Application for Removal or Variation of a Condition following Grant of Planning Permission or Listed Building Consent

Reservoir Road

Erection of single storey side and rear extensions to include a flat roof with low parapet (Amendment to previous Planning Approval Ref: 50293/APP/2016/4418 - Single storey side extension and single storey rear extension.)

50293/APP/2021/4560

Drawing Number
reservoirrd-59 / 6 REV K
proposed elevations

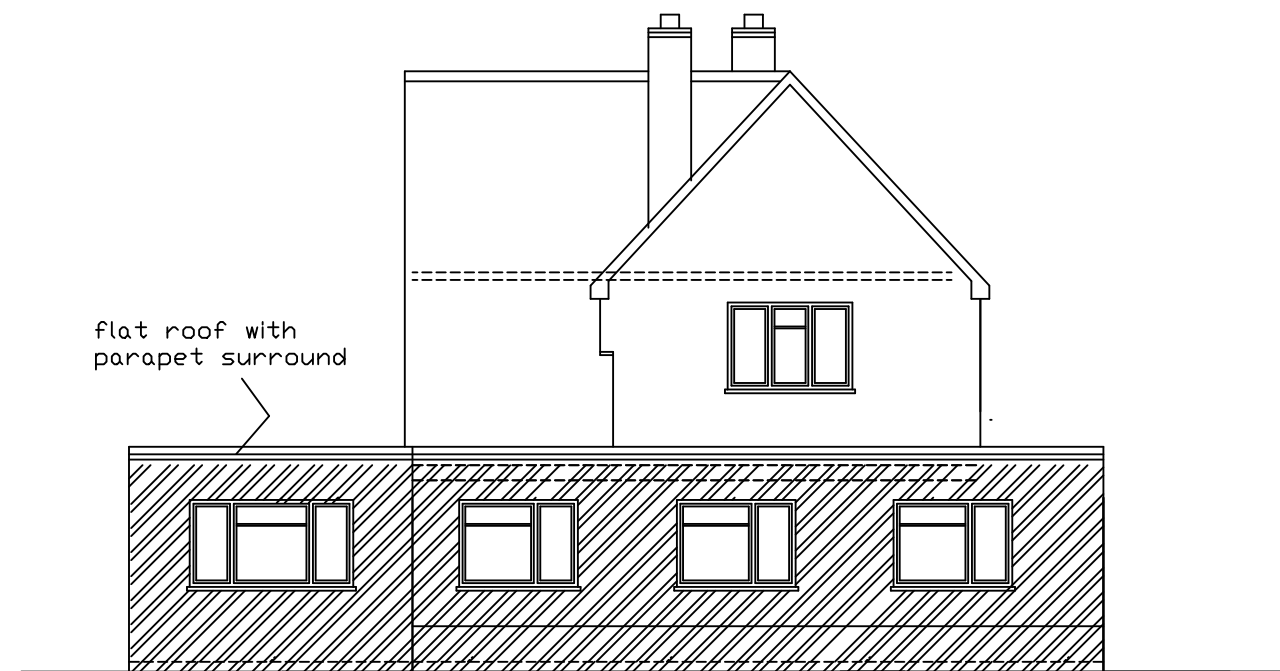
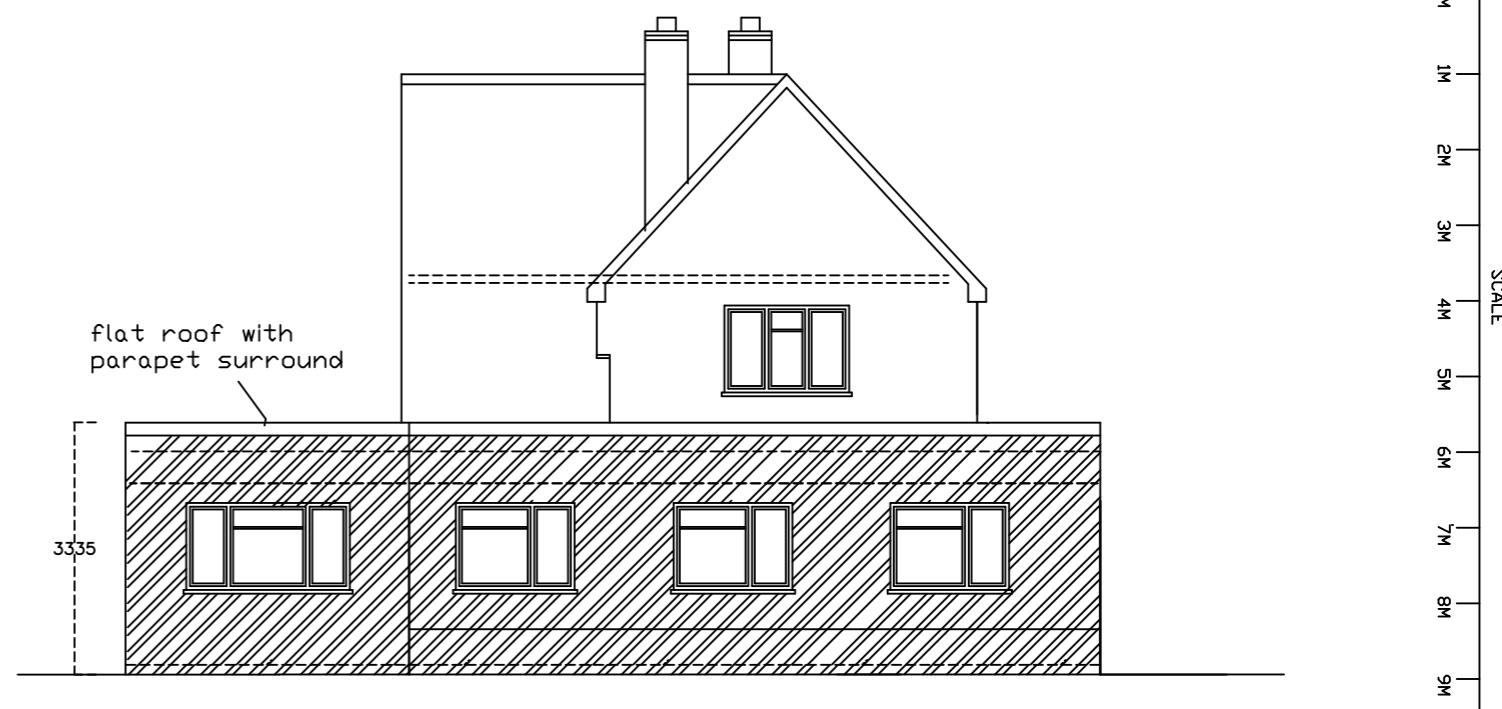
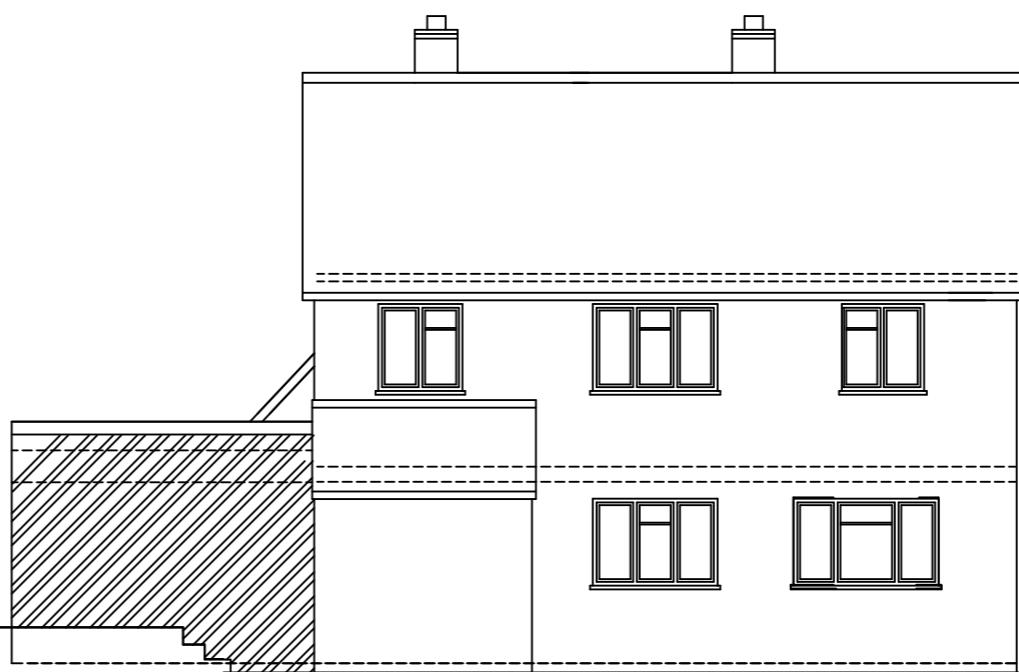
The parapet has been built slightly higher to comply with subsequent Building Regulation requirements, hence the need for the retrospective application to regularise the situation. It is only marginally higher and therefore has no material impact on the design of the building and the wider street scene.

Plan numbers - reservoirrd-59/6revg is to be replaced with - reservoirrd-59/6revk

Drawing Number
 reservoirrd-59 / 1 REV K
 proposed ground

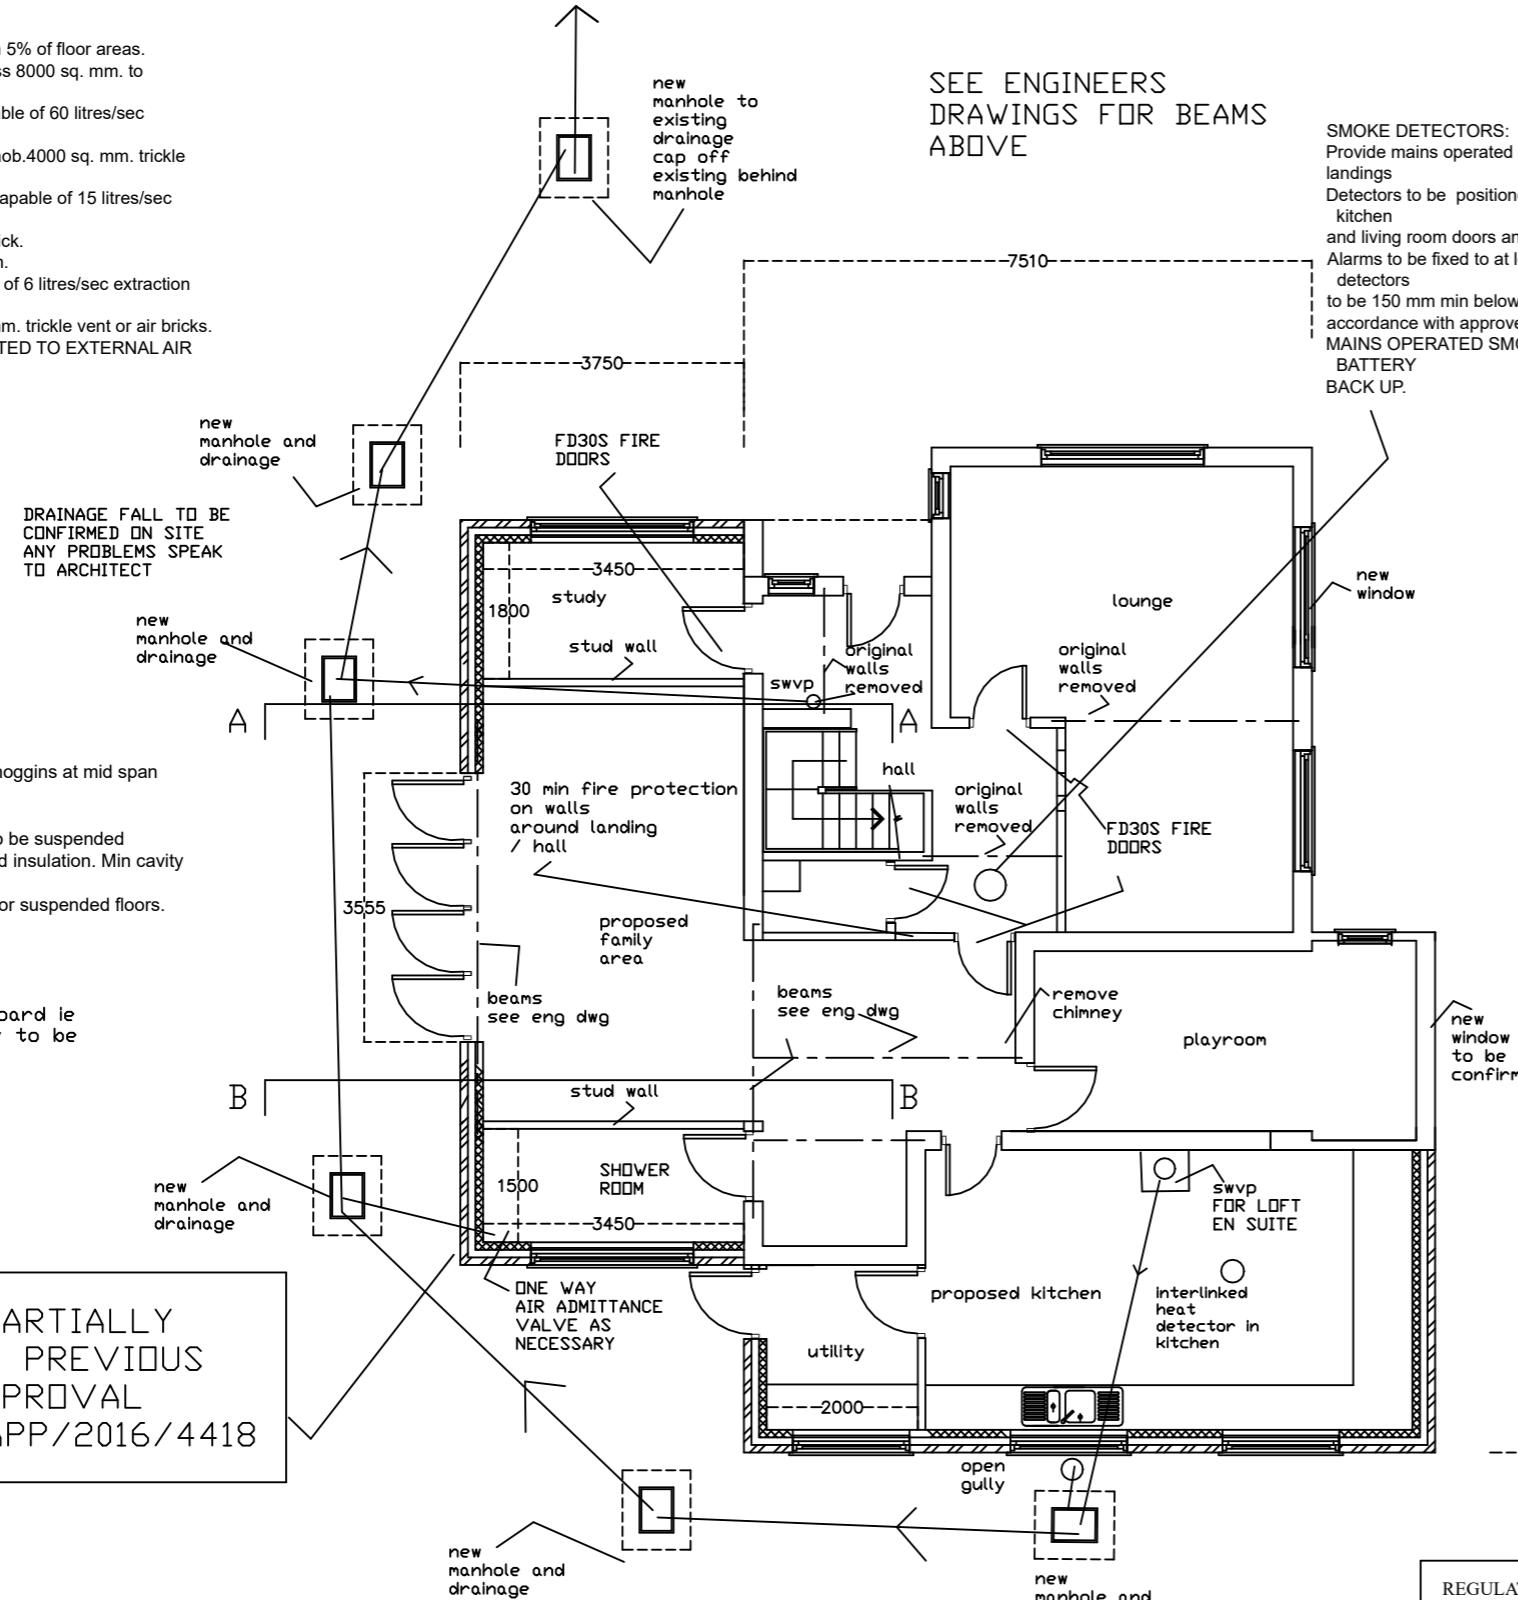
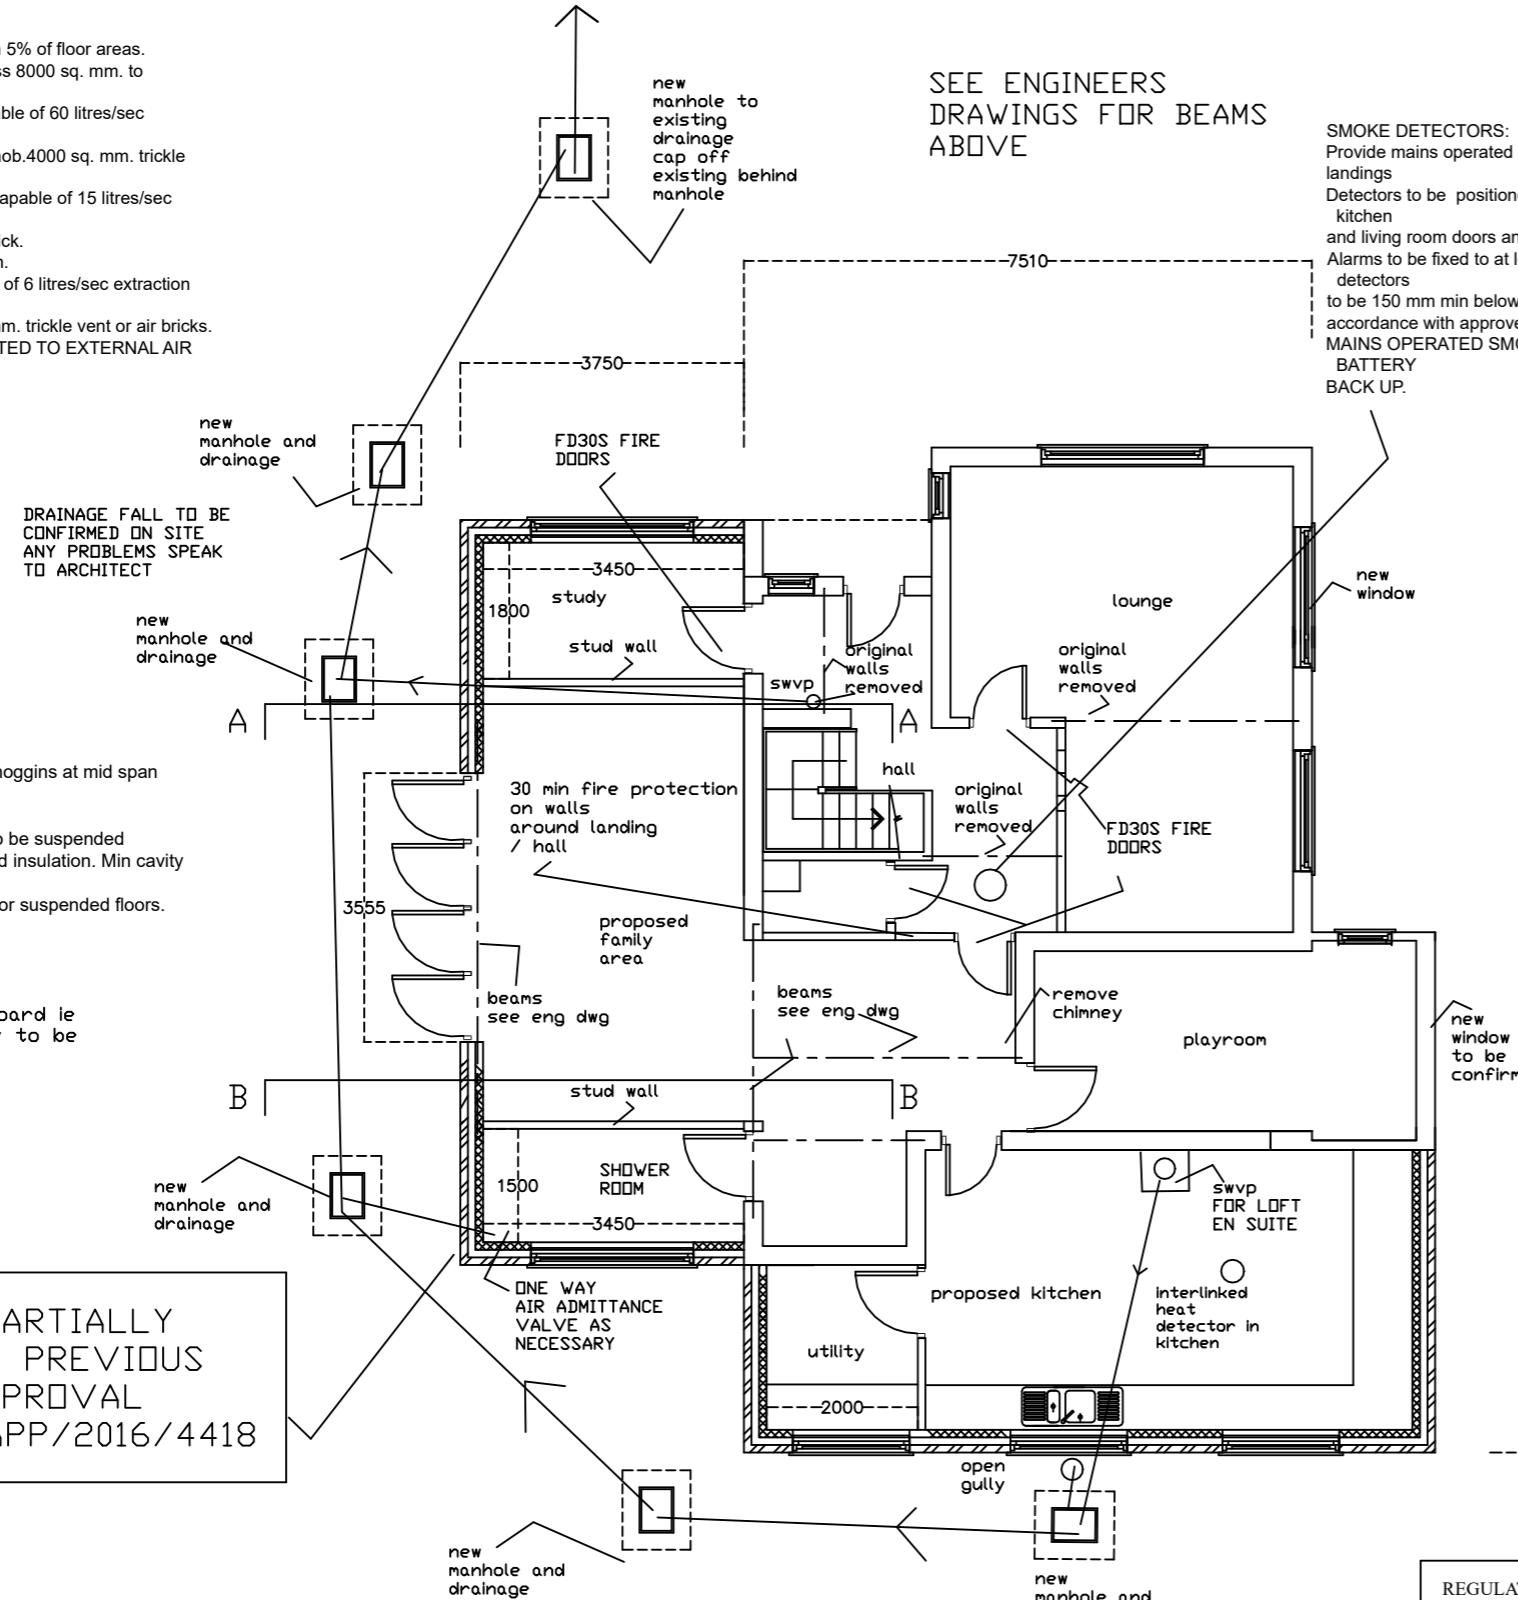
Secondly, the utility room external door has been omitted from the scheme.

Plan numbers - reservoirrd-59/1revg is to be replaced with - reservoirrd-59/1revk
